Please ask for: Ms Iqraa Malik
Email: iqraa.malik@terraquest.co.uk
Telephone: 0121 234 1390
Our Ref: R/194/24/HH
Your Ref:
Date: 14th October 2024

Application for Planning Permission for Works or Extension to a Dwelling

Development: Retrospective application for the erection of a garden shed and fencing.
Location: 19 Orchard Gardens Rustington BN16 3HN

Site Plan - Existing state
1:100 @ A3

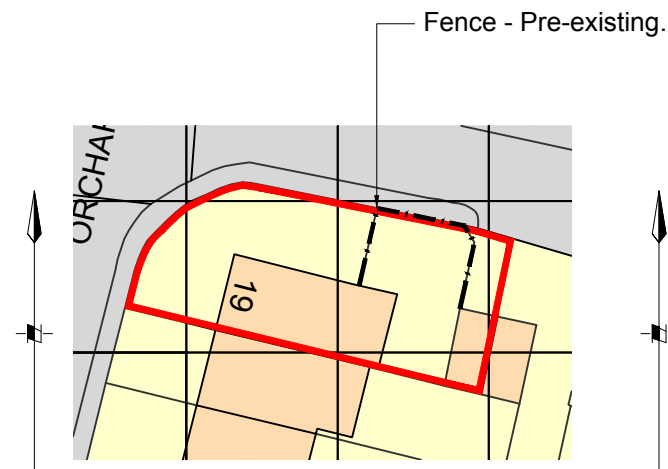
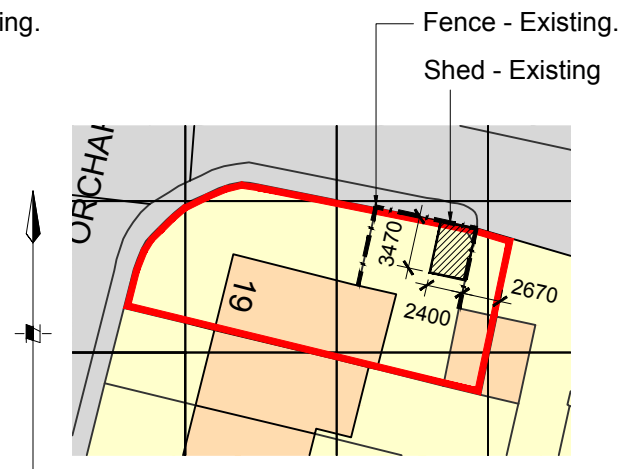
Please amend the site plans to show the location of the pre-existing and existing fence.

Please re-label the submitted plans to pre-existing and existing.
